WEST SUSSEX COUNTY COUNCIL CONSULTATION

TO:	Arun District Council FAO: Andrew Wood
FROM:	WSCC - Highways Authority
DATE:	23 May 2019
LOCATION:	Unit 1 Bullocks Yard Ford Lane Ford BN18 0EF
SUBJECT:	F/12/19/PL Change of use from boat & marine leisure yachts manufacturer to vehicle MOT testing station. This application may affect the setting of a listed building.
DATE OF SITE VISIT:	
RECOMMENDATION:	More Information
S106 CONTRIBUTION TOTAL:

Unit 1 - Location Plan

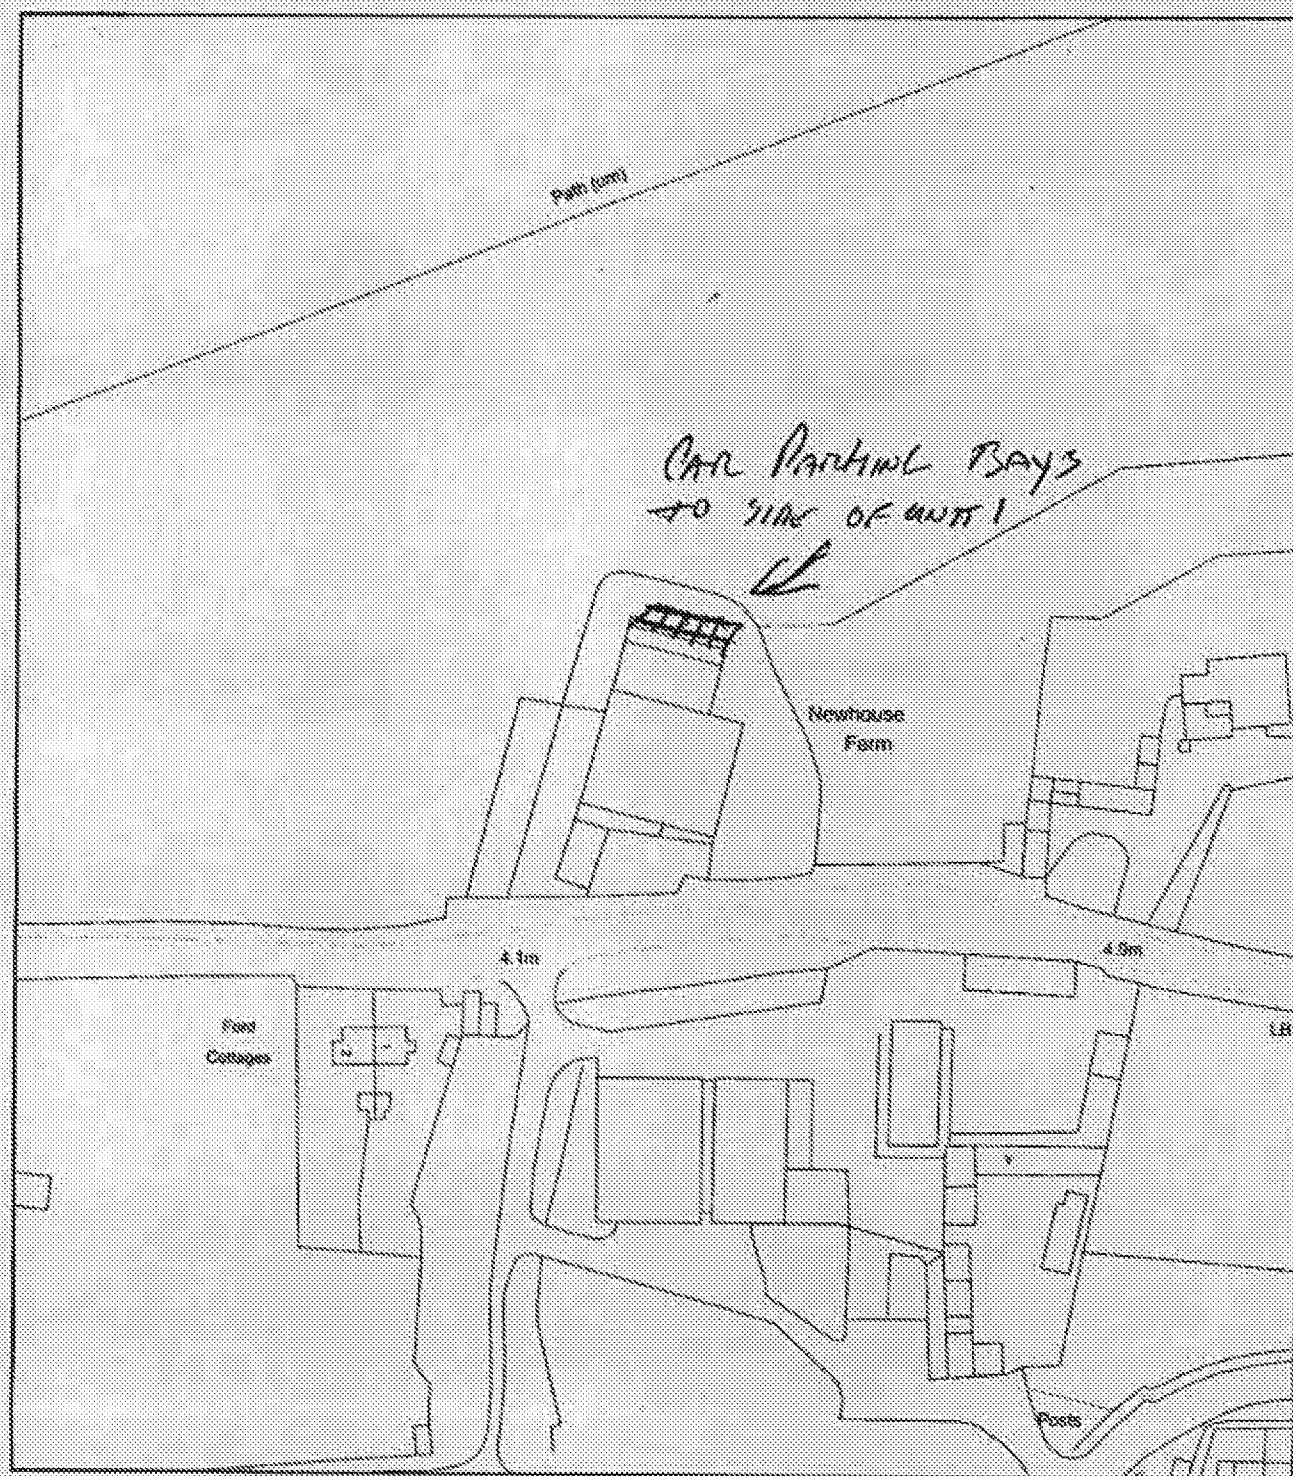
- The current trip rate of vehicles on and off the site,
- The proposed trip rate of vehicles on and off the site,
- Plan showing maximum Vehicle Visibility Splays,
- Detailed plan showing the extent of parking on site, with marked bays for employees and visitors, along with location for storage of vehicles.
